Your Ref: **ACP-323780-25**

Our Ref: **SID-LK-2025-024**

31 October 2025

Proposed Strategic Infrastructure Development (SID): REDIII Application planning application for the construction of a Wind Energy Project within the townlands of Ballincurra, Ballingayrou, Ballinlee South, Ballinlee North, Ballinrea, Ballyreesode, Camas North, Camas South, Carrigeen, Knockuregare, Ballybane, Ballynanty, Cahirguillamore, Rockbarton, Grange, Ballynagallagh, Skool, Friarstown South, Friarstown, Rockstown, Rochestown, Carriganattin, Stonepark, Ballynagarde, Ballymacgreese, Glen, Knockbrien, Ballyneety, Scart, Ballyogartha, Carrigmartin, Cahernarry (Cripps), Drombanny, Ballybrennan, Coolyhenan, Knockananty, Ballysimon Commons, Tullovin, and Milltown, Co. Limerick.

Figure 4-2: Map of proposed location of wind turbines

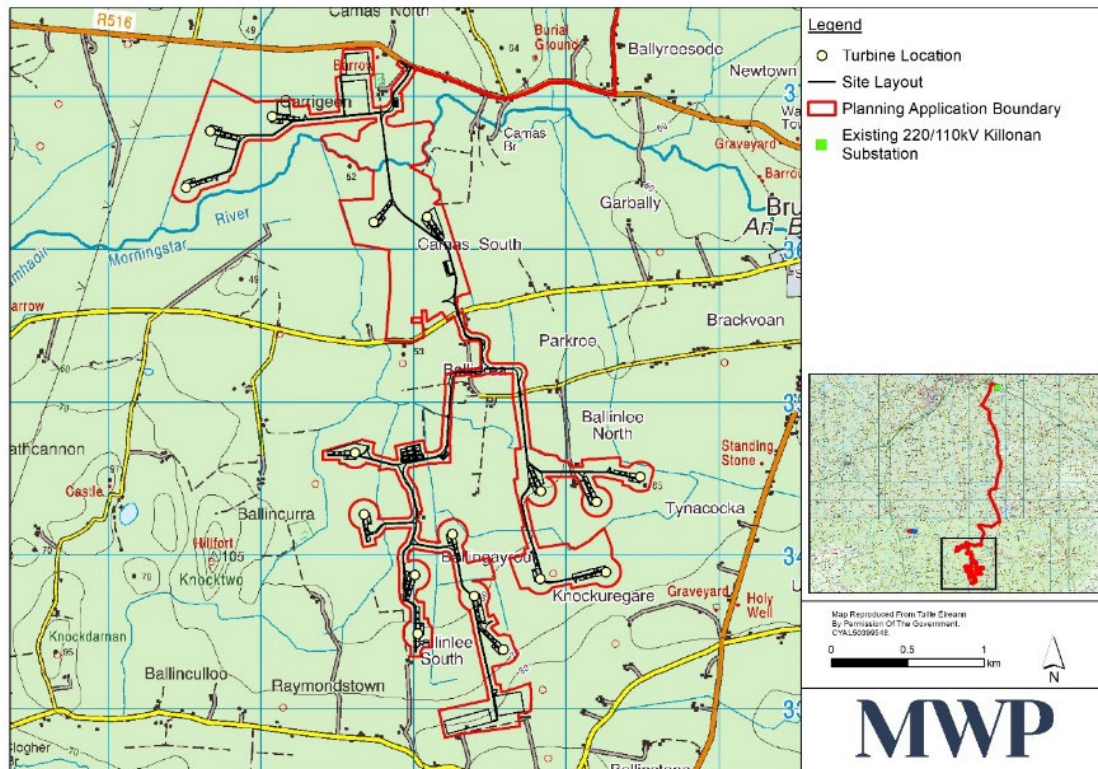
- T01 is located within the midst of a cluster of five barrow sites: LI031-151001-; LI031-151002-; LI031-151003-; LI031-151004-; LI031-151005-. This suggests the turbine is in the middle of a barrow cemetery which could include further barrow sites and other burial or ritual features such as cist burials or urn burials. This potential and the direct negative impacts to such a cemetery have not been explicitly assessed.

Figure 4-11: Map of proposed permanent deposition areas

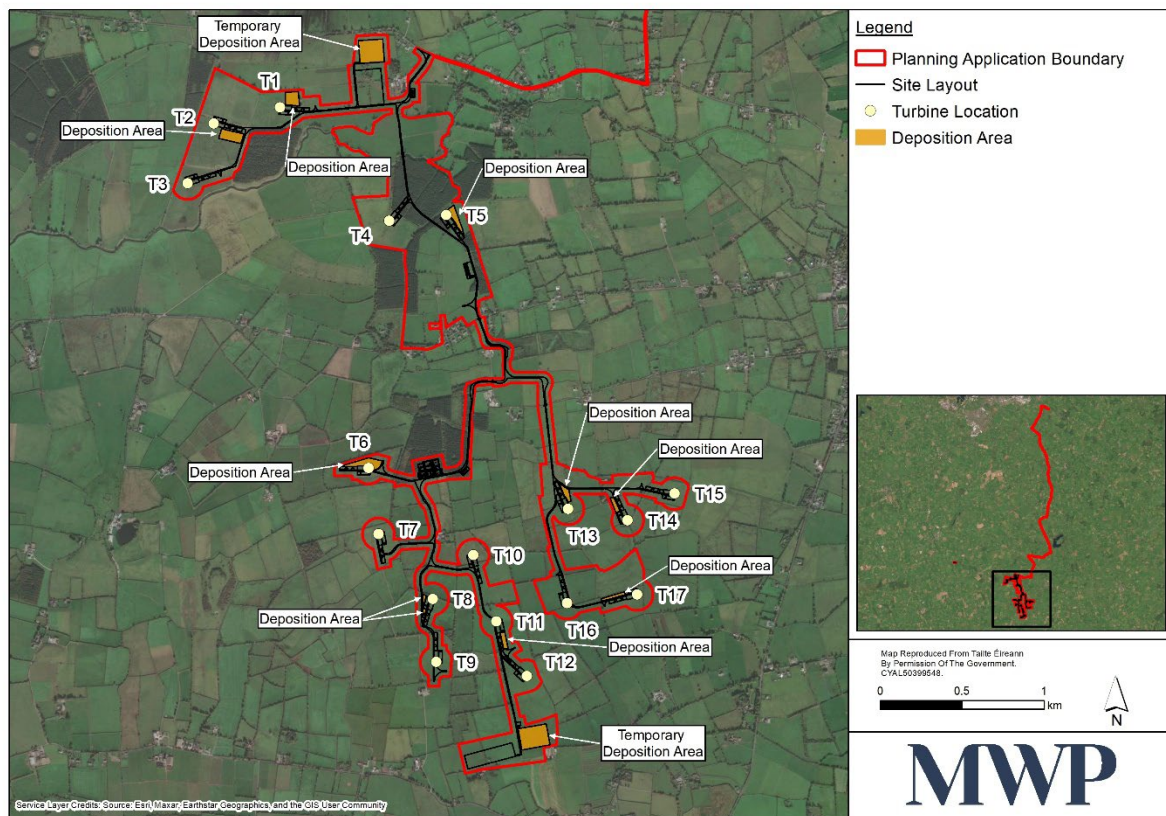
- Deposition Area to the north of Borrow Pit 1 may partially incorporate the footprint of ring-barrow LI031-127---- so there is a potential of direct impacts to this site. In addition, the location of barrow LI031-152---- to the north and mound LI031-126---- suggest that this deposition area has also been located in the middle of a barrow cemetery. This potential and the direct negative impacts to such a cemetery have not been explicitly assessed.
